City of Portland, Maine - Building or Use Permit Application

Permit No: 03-1143	Issue Date: SEP 18 2003	CBL: 368 A014001
-----------------------	----------------------------	---------------------

Proposed Project Description: Build 8x10 wood frame shed	Signature: <i>JMB</i> 9/18/03
PEDESTRIAN ACTIVITIES DISTRICT (P.A.D.)	
Action: <input type="checkbox"/> Approved <input type="checkbox"/> Approved w/Conditions <input type="checkbox"/> Denied	
Signature:	Date:

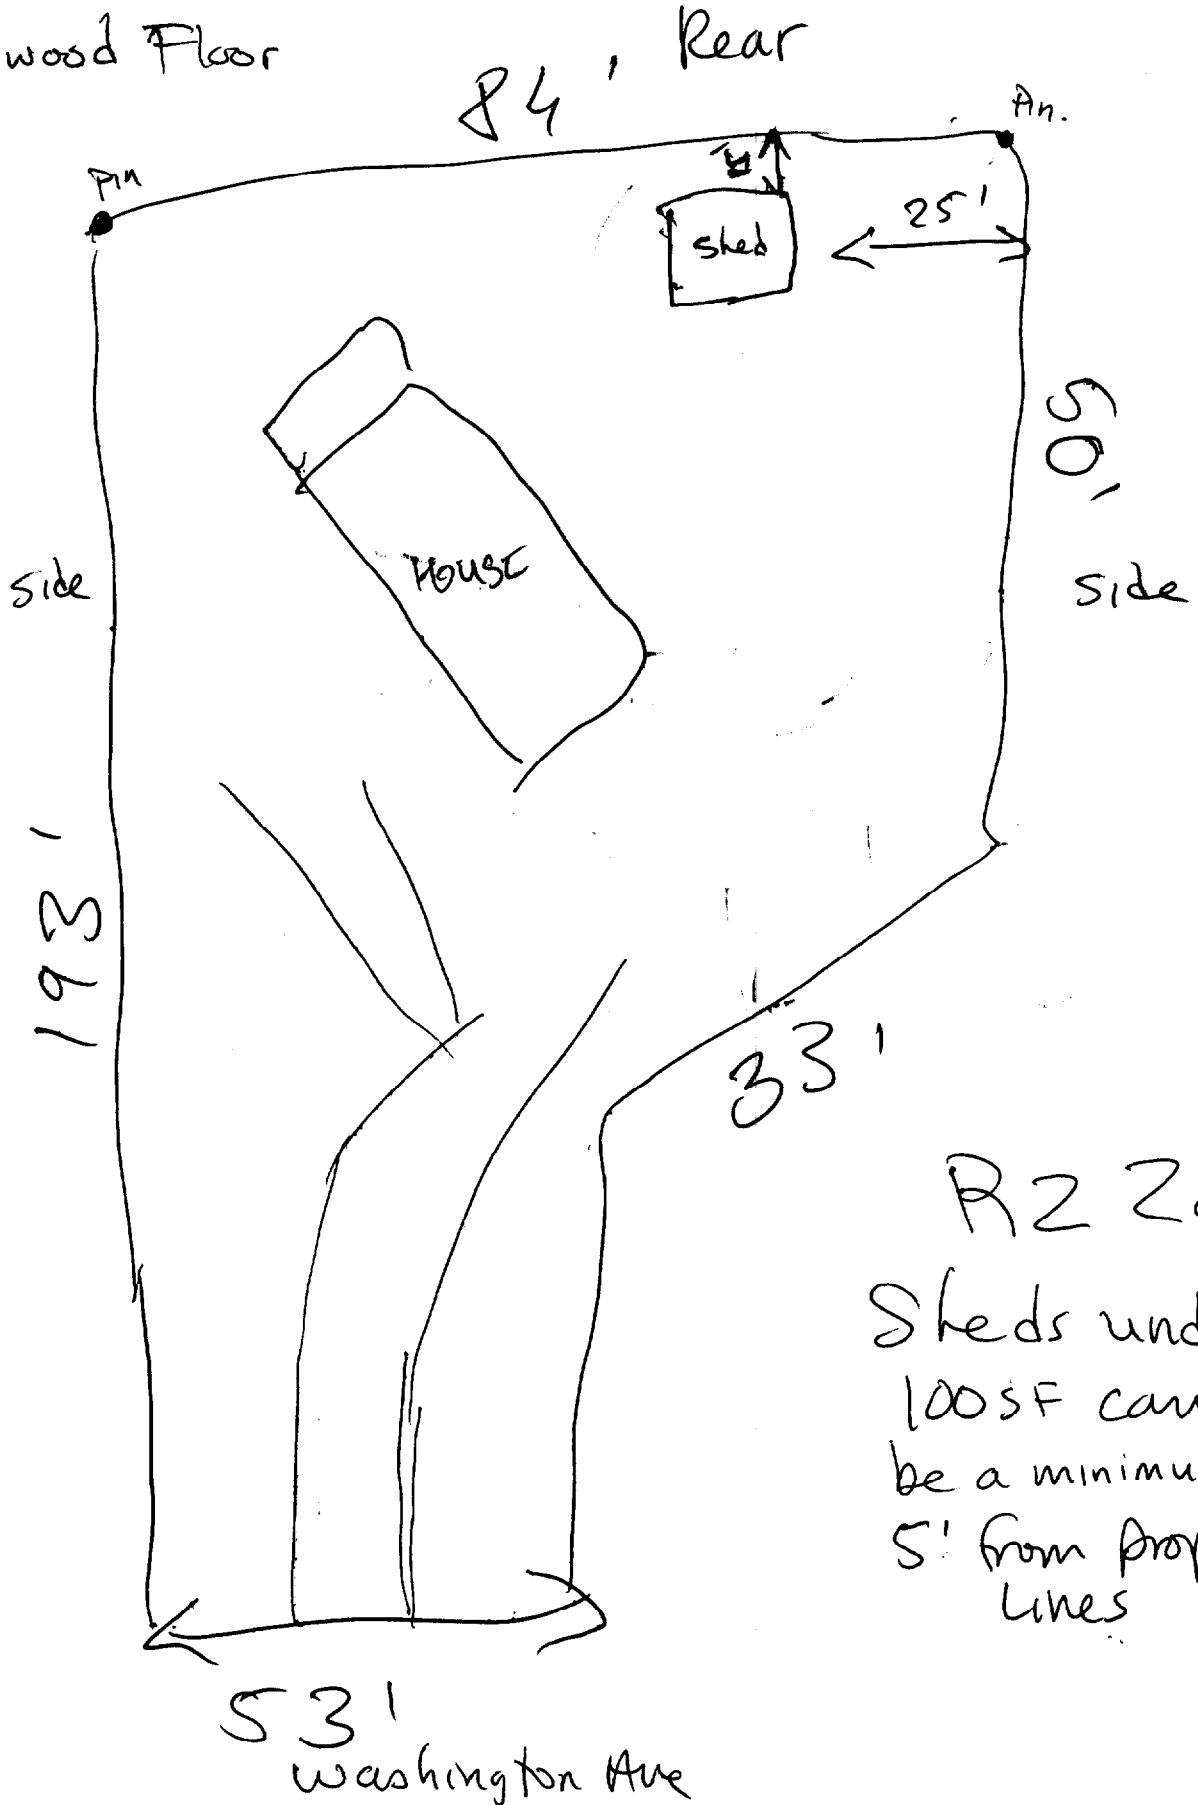
1) Roof must have minimum 2x6 rafters 16 O. C. And 1/2" plywood sheets
 Floor must have minimum 2x6 joists 16 O. C.
